Hampshire Water Transfer and Water Recycling Project

Environmental Statement – Figure 8.3 Non-statutory designated sites within the desk study area

17 July 2026

Document Control		
Title	Environmental Statement – Figure 8.3 Non-statutory designated sites within the desk study area	
Version History		
Version	Date	Status/Reason for Issue
Version 0	21 May 2026	DCO Submission
Version 1	17 July 2026	S51 Advice

Figure 8.3
 Non-statutory designated sites within the desk study area
 Sheet 4 of 16

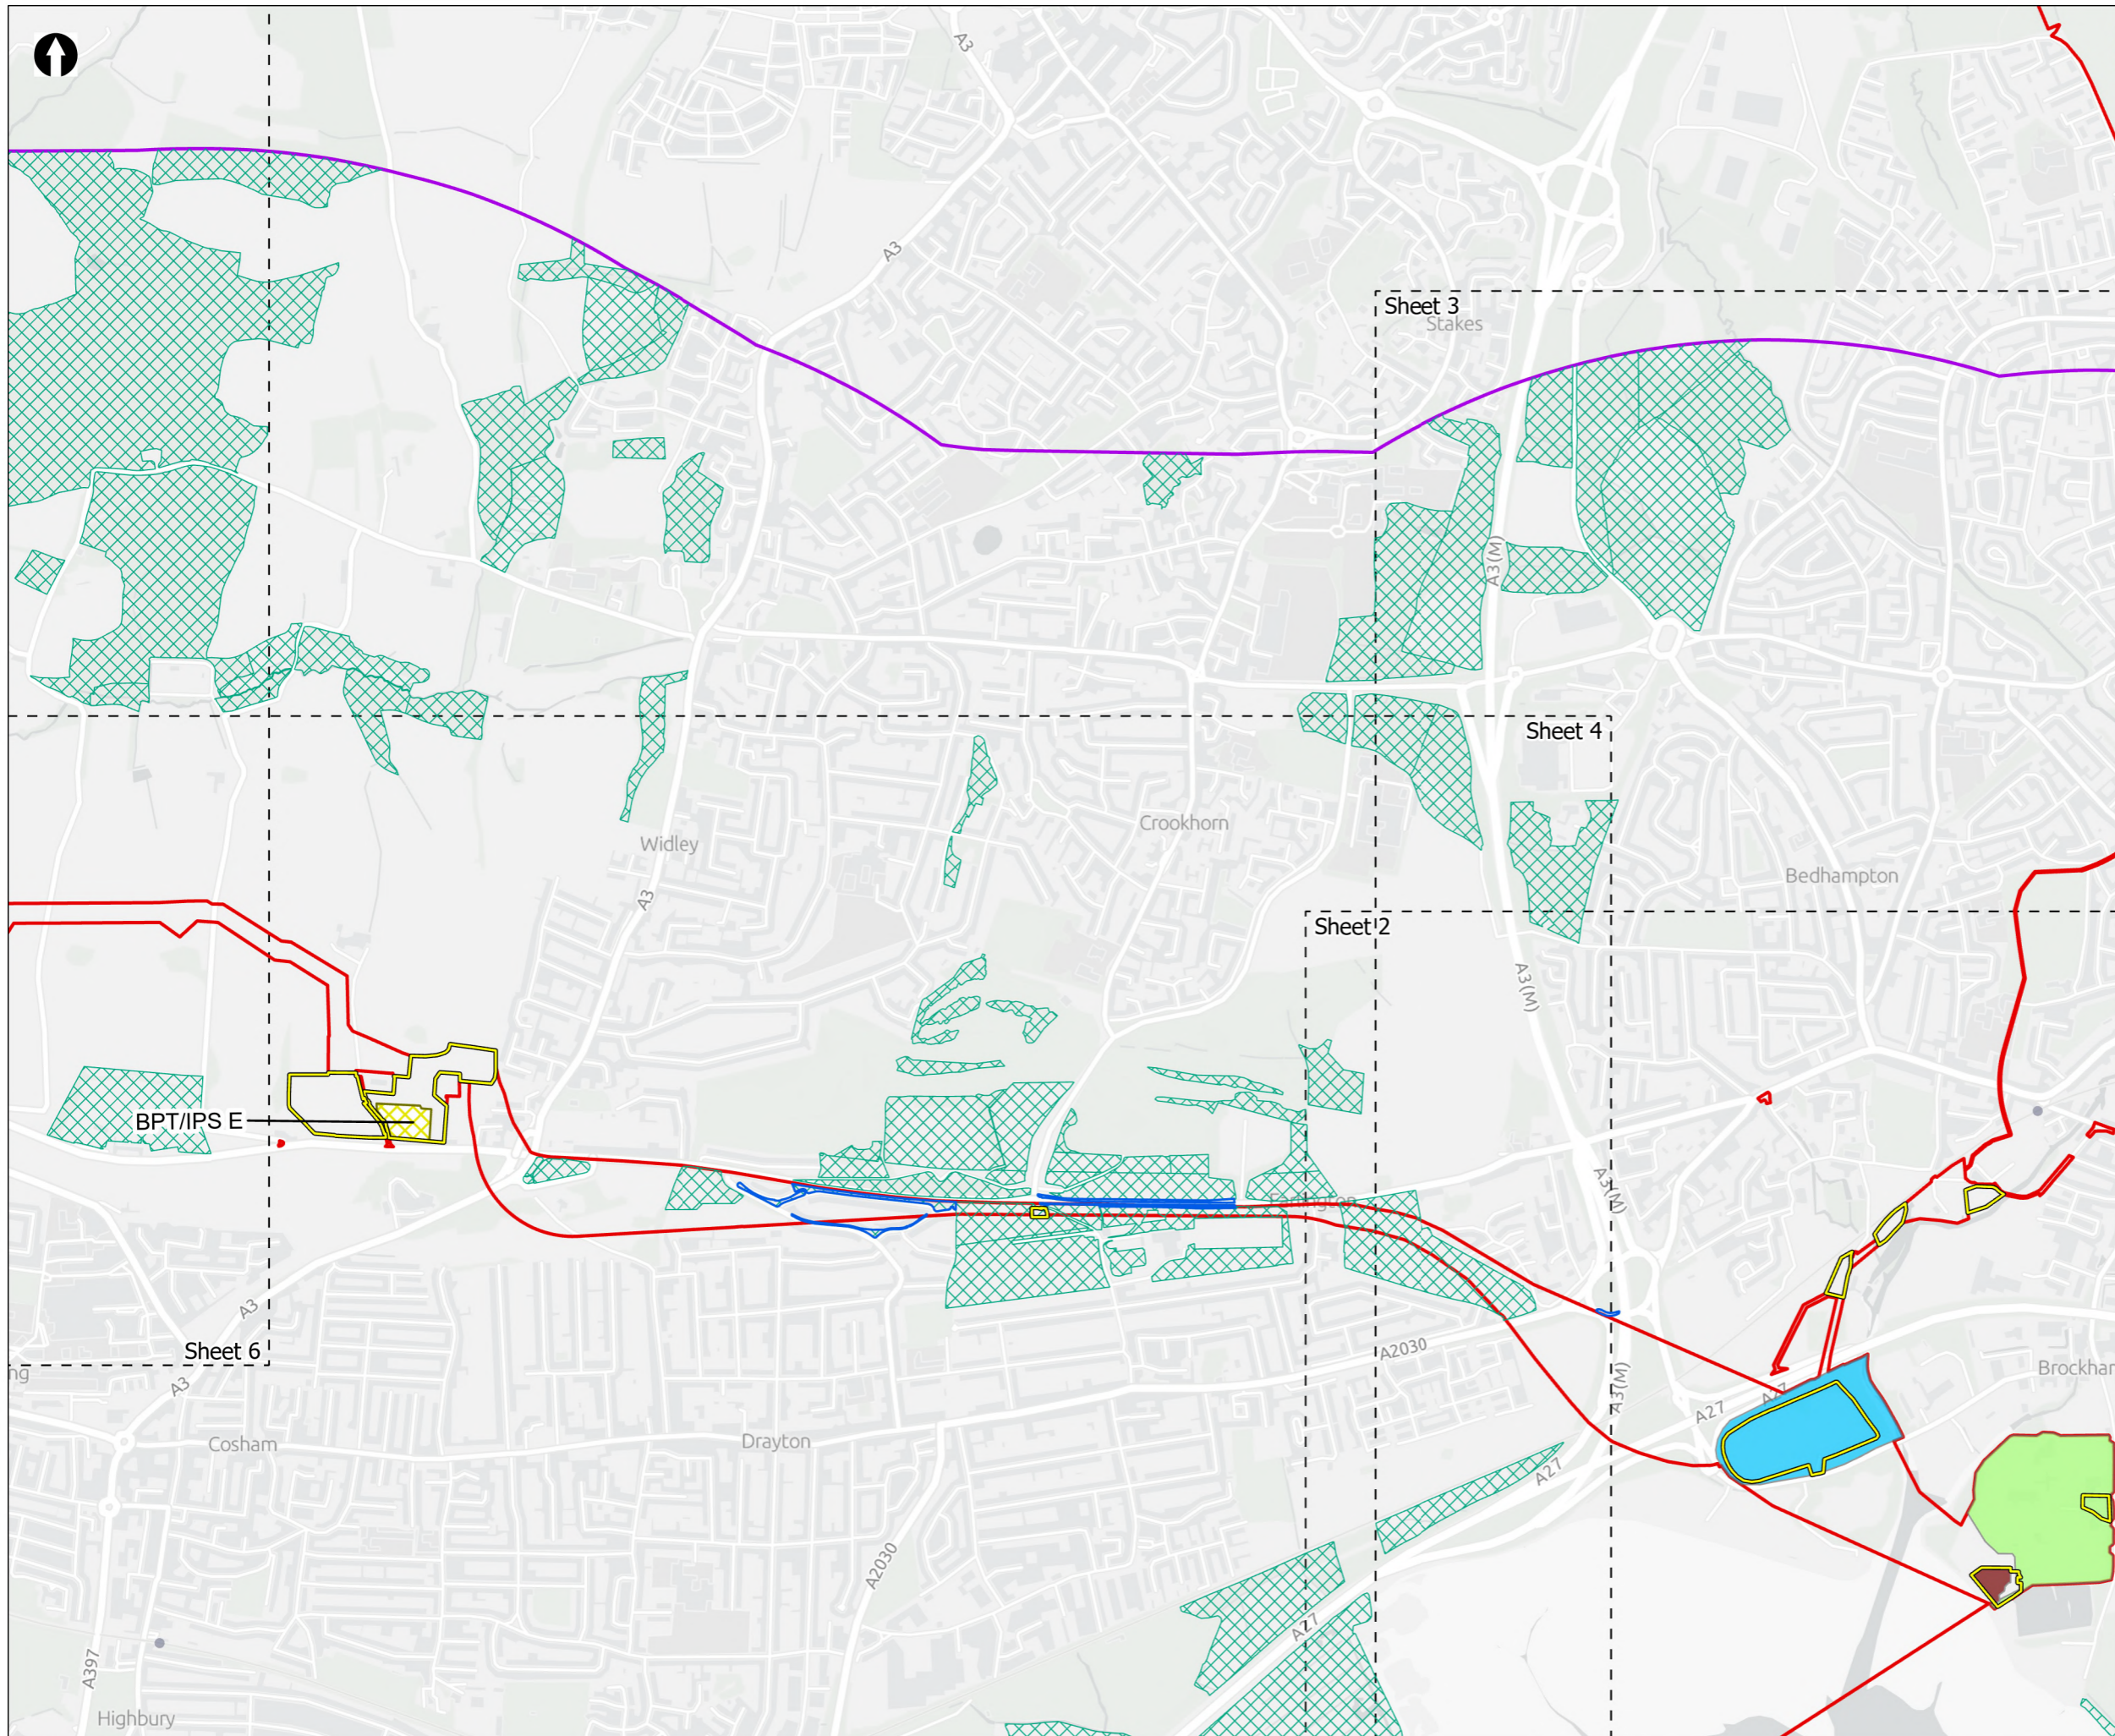
Drawing Number	Drawing Title	Updated Revision	Changes
17 July 2026 – Response to S51 Advice			
ES Vol III – ES Figure 8.3 Non-statutory designated sites within the desk study area			
PC5223-RHD-ES-ZZ-D-Z-0028	Figure 8.3 Non-statutory designated sites within the desk study area SHEET 4 OF 16	06	All Sites of Interest for Nature Conservation (SINC) and Road Verges of Ecological Interest (RVEI) included in the ecology assessment (ES Chapter 8) added to figure: • Field West of Gillman Road SINC • Birkdale Avenue RVEI • Land to the South of Portsdown Hill Road SINC
PC5223-RHD-ES-ZZ-D-Z-0028	Figure 8.3 Non-statutory designated sites within the desk study area SHEET 5 OF 16	06	All SINC and RVEIs included in the ecology assessment (ES Chapter 8) added to figure: • Field West of Gillman Road SINC • Birkdale Avenue RVEI • Land to the South of Portsdown Hill Road SINC
PC5223-RHD-ES-ZZ-D-Z-0028	Figure 8.3 Non-statutory designated sites within the desk study area SHEET 6 OF 16	06	All SINC and RVEIs included in the ecology assessment (ES Chapter 8) added to figure: • Motte & Bailey & Chalk Pit SINC

Figure 8.3
 Non-statutory designated sites within the desk study area
 Sheet 14 of 16

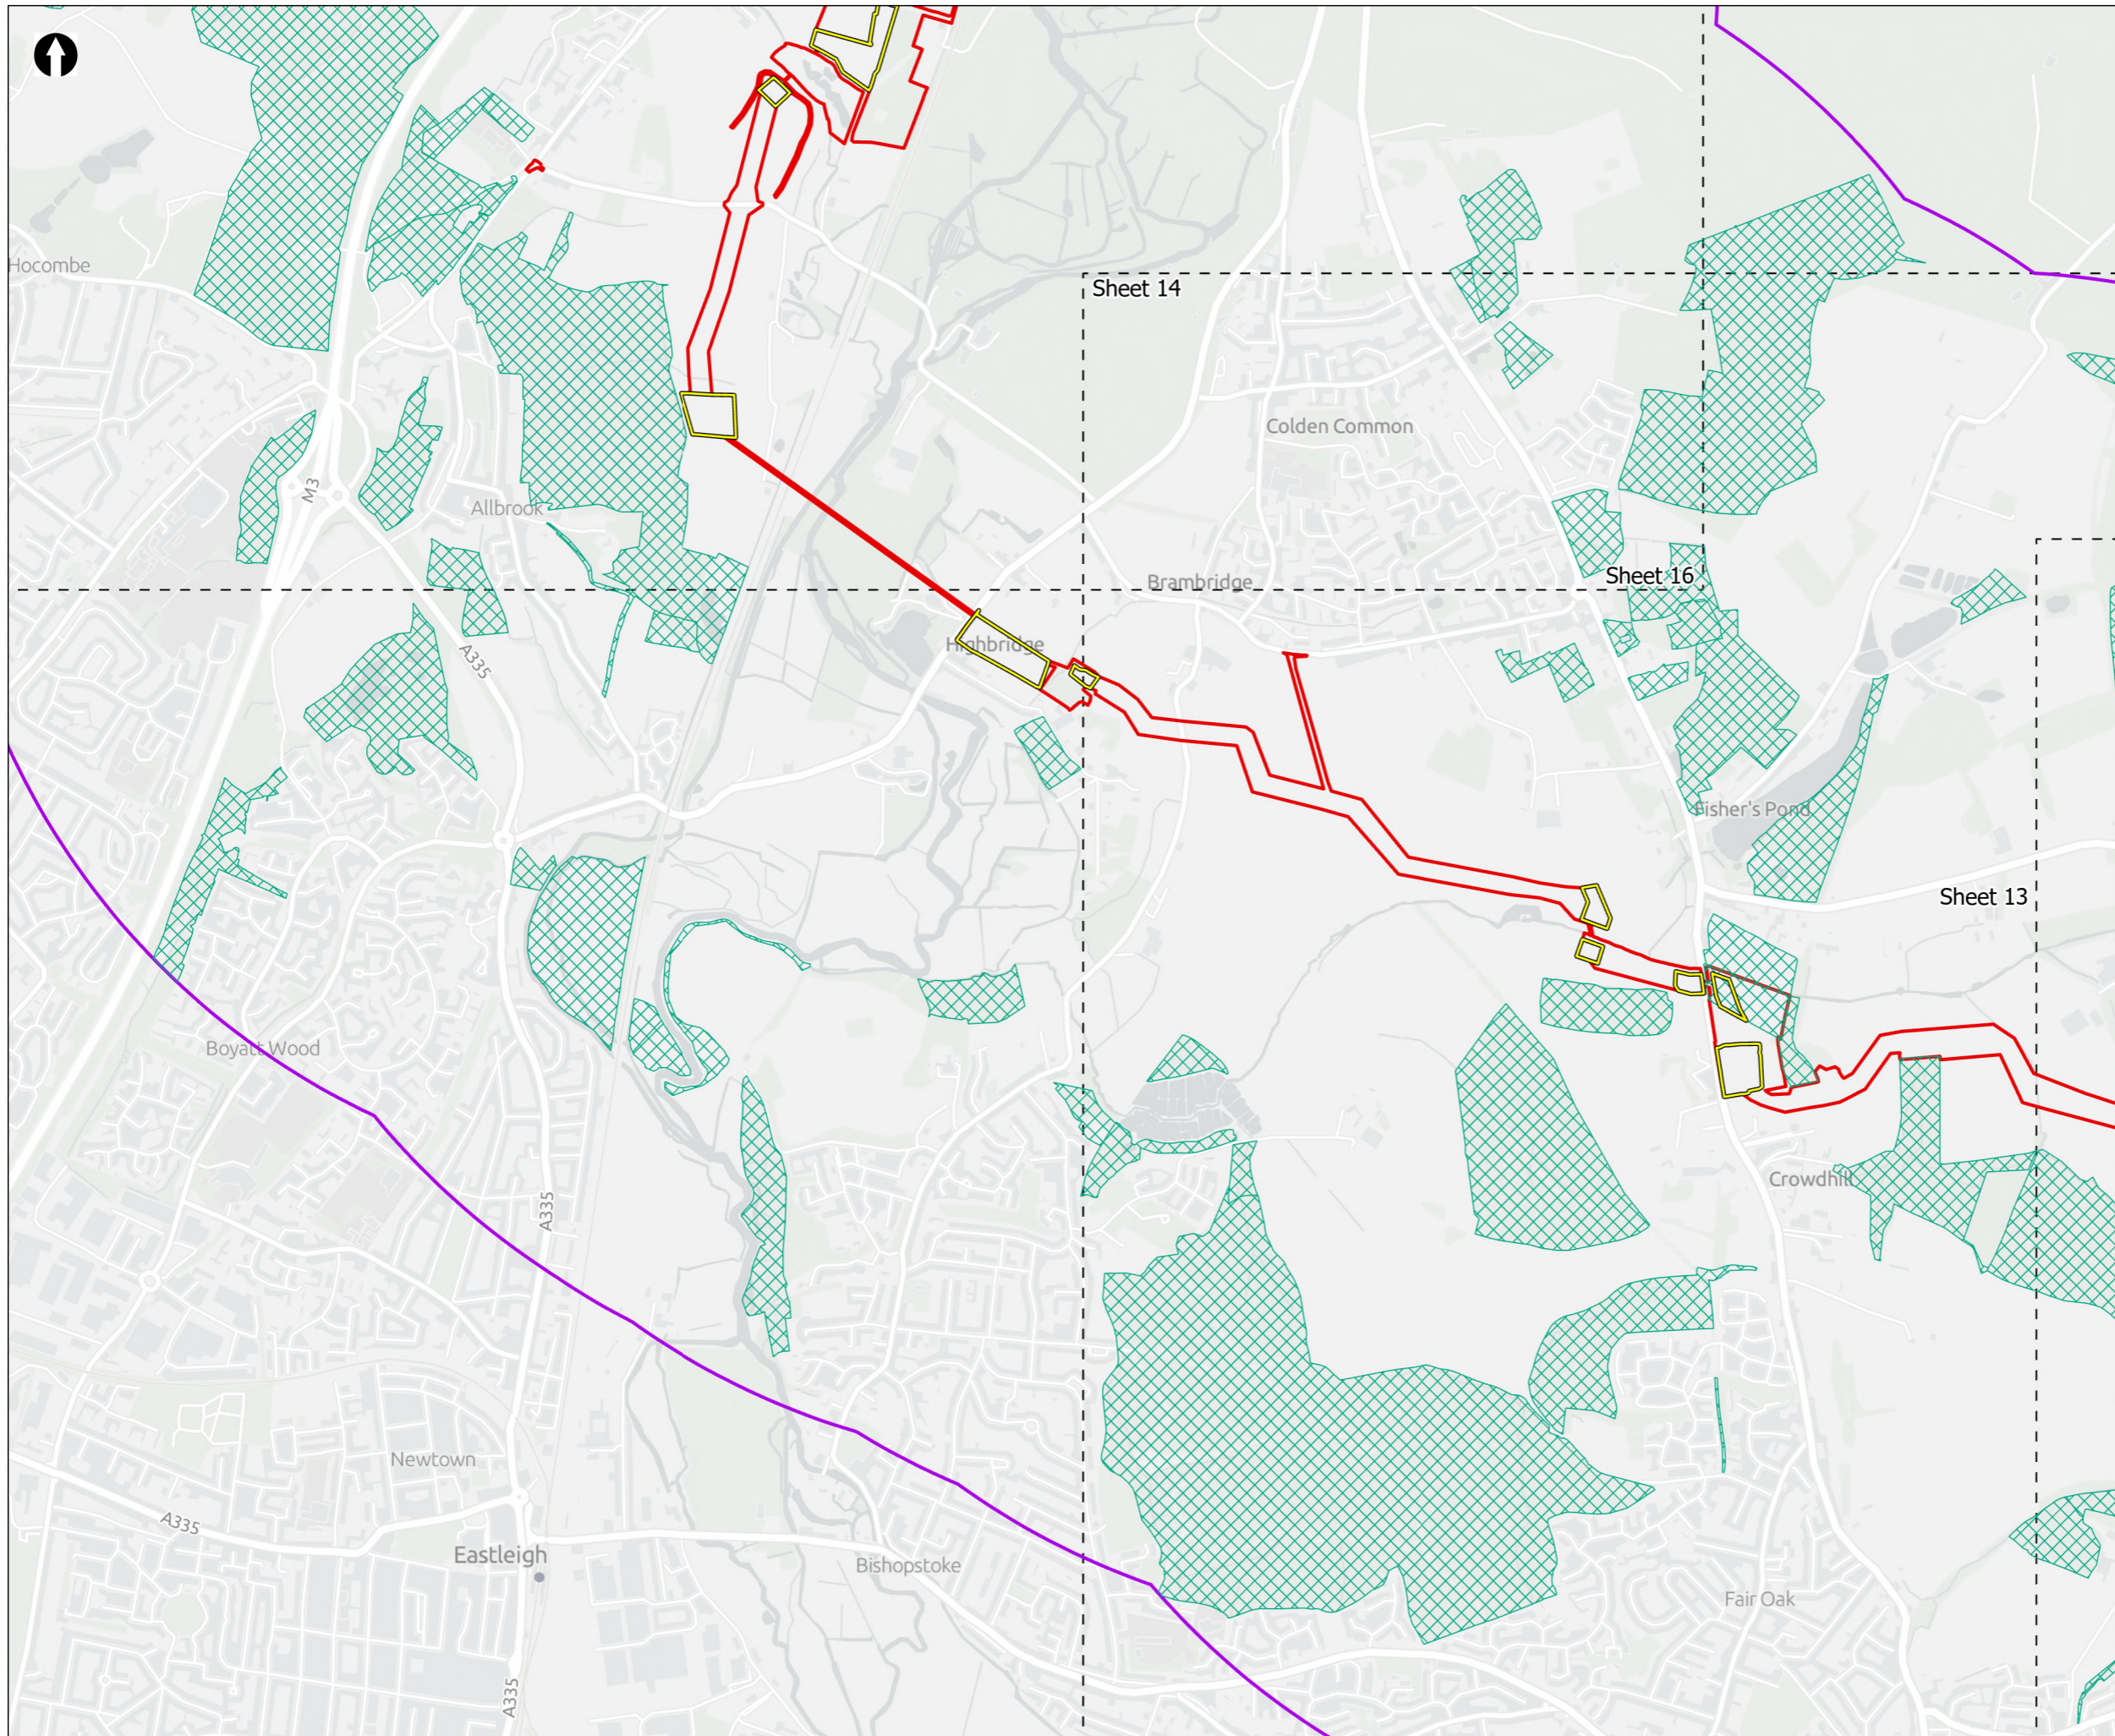
PC5223-RHD-ES-ZZ-D-Z-0028	Figure 8.3 Non-statutory designated sites within the desk study area SHEET 14 OF 16	06	All SINC's and RVEIs included in the ecology assessment (ES Chapter 8) added to figure: • Gore Copse SINC • Chestnut Gully Wood SINC • The Mount Fair Oak and Horton Heath SINC • Fielders Farm Meadows (Eastleigh) SINC • Colden Common Wood and Bracknells Copse SINC • Stoke Park Wood SINC
